Please find additional / new comments from the open floor hearing.

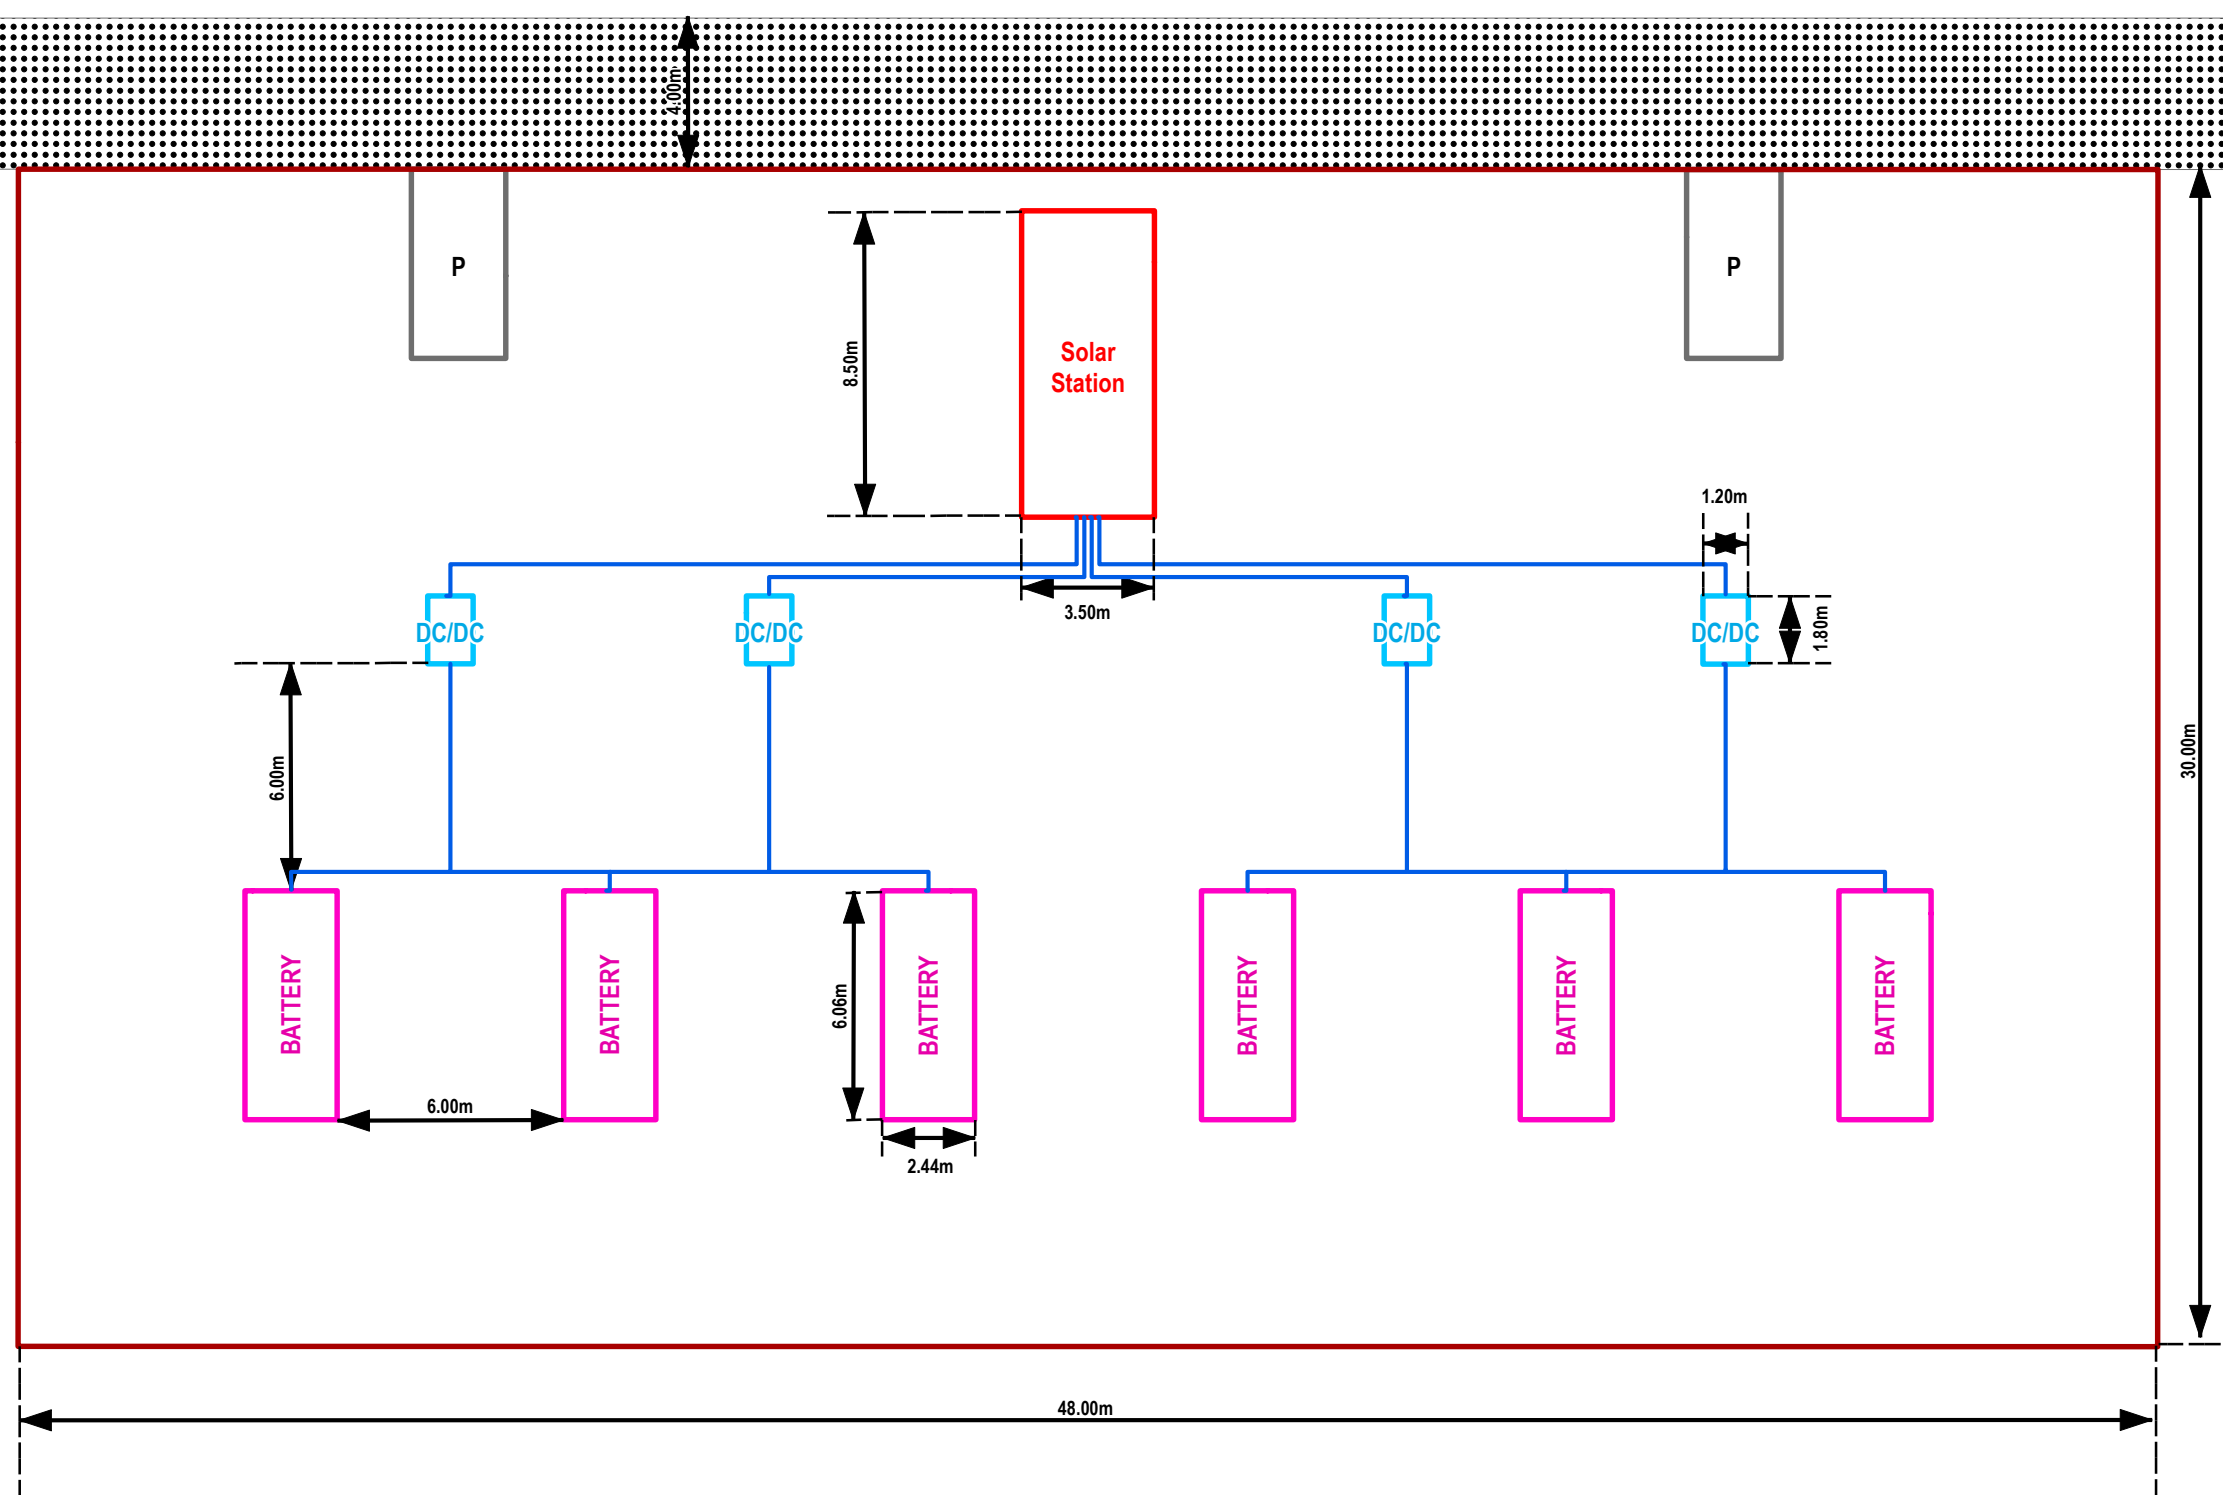
3, BESS, I fail to understand the requirement of these verses the local impact re noise and fire risk. The length of storage period I understand is only several hours, is this a real benefit in the scale of things? The information provided is scant and therefore I would question the effects of noise / fire risk / health of locals verses the need.

4, Fire, looking at the positioning of the BESS access by the emergency services is limited with difficult surfaces to navigate Water provision / access is going to be a major concern as the highest volume of water is the river Trent several miles away. The current thinking to control a fire within a BESS is to water cool and let it burn out which then raises questions as to both the contamination of the land and welfare of the local population. The contaminated cooling water unless bunded will enter the local water course and eventually find its way to the river Trent leaving pollution in its tracks.

BESS fires have already resulted in the evacuation & implementation of local emergency plans depending on the wind this may affect thousands of people locally – how will this be dealt with?
